Planning Application: Seeking advice on an **OUTLINE** planning application for the construction of up to 175 new dwellings on this site with associated road network and access arrangements.

Reference: **WA/44/17/OUT**

Location: **Land east of Tye Lane, Walberton**

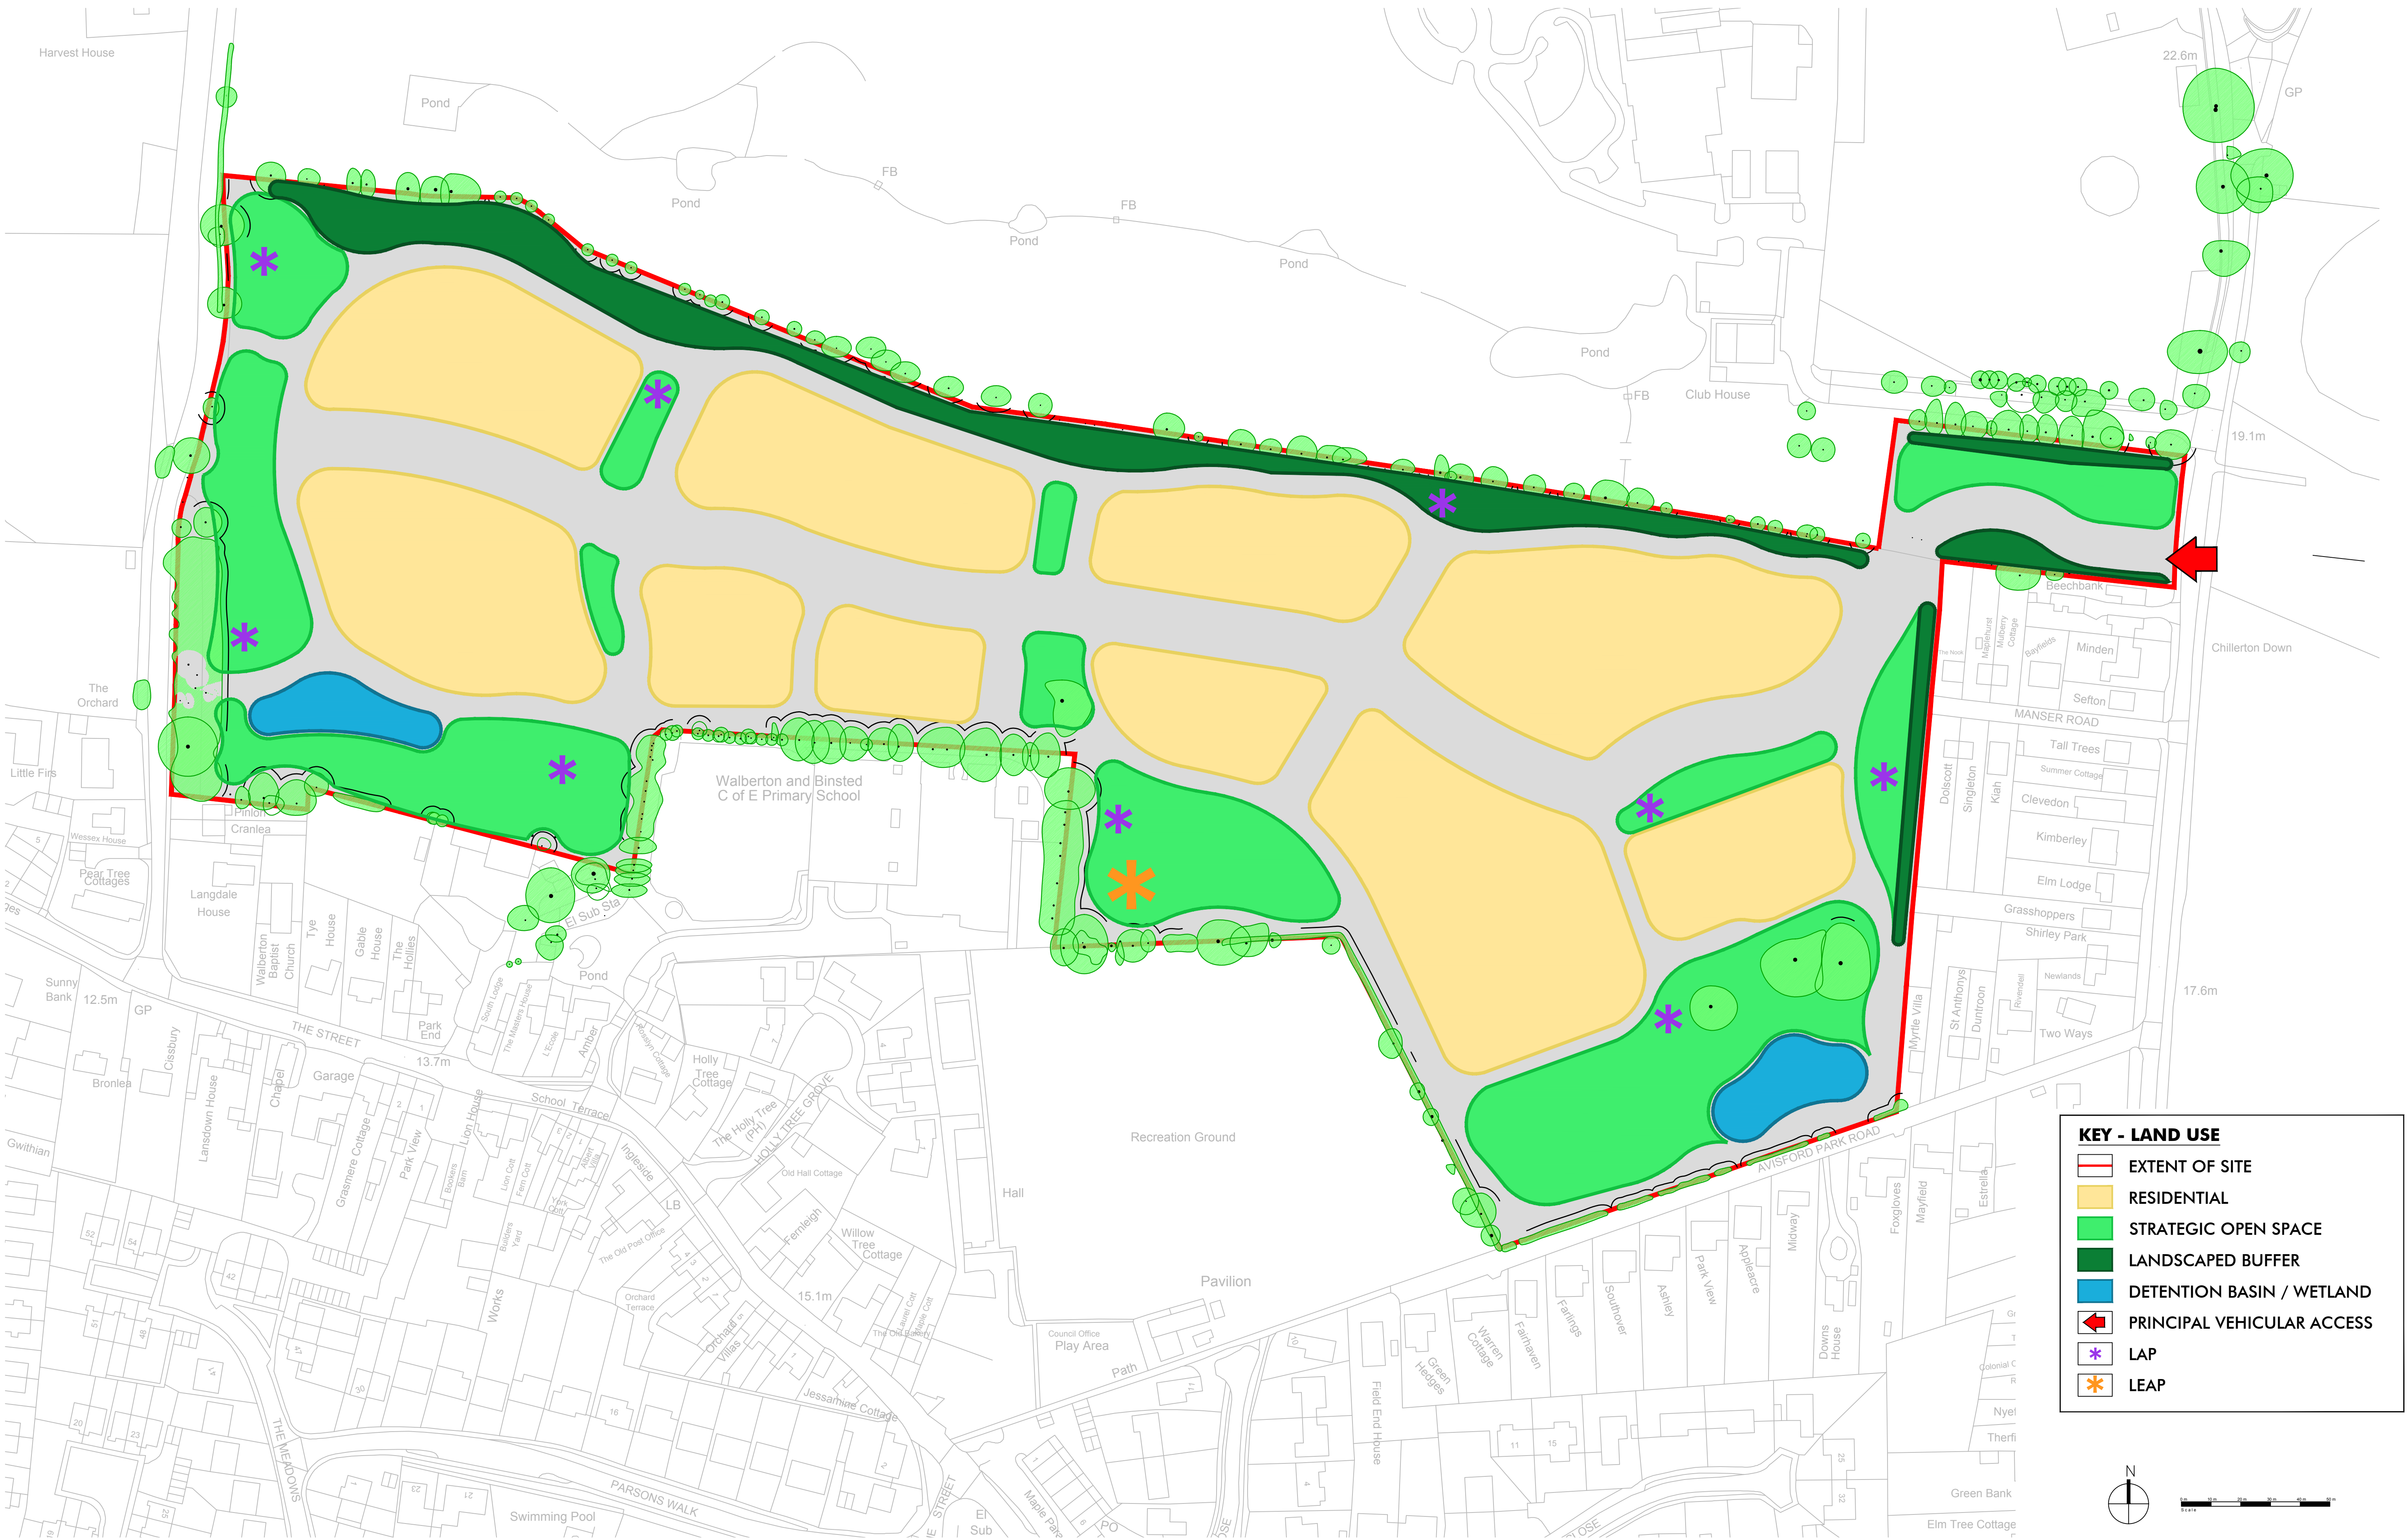
- A Method Statement has also been included which fairly assesses the constraints and recommends design solutions to same but these do not as yet appear to have been reflected on the Planning Layout Drawing. I am generally happy with the overall layout of the dwellings on this site but have issues with the footpath locations many of which needlessly cut through tree RPA's when there is adequate room on this site to re-route them all outside of same and avoid any conflict.

- Major trees have been left on areas of open space which is good but then their RPA's have been shortened back to allow for the footpath to be dug through them – I would wish this to come back in at the Full Planning stages with these paths moved outside of the RPA's.

- Until the footpath/drives/roads are moved outside of RPA's I would have to register an **OBJECTION** to this scheme.

- I would wish to see this come back in at the FULL planning application stage showing no intrusion into tree RPA's by footpaths and access drives and roads.
- I recommend that a TPO is made to protect four trees that make a significant impact in the landscape and should be afforded full protection status.
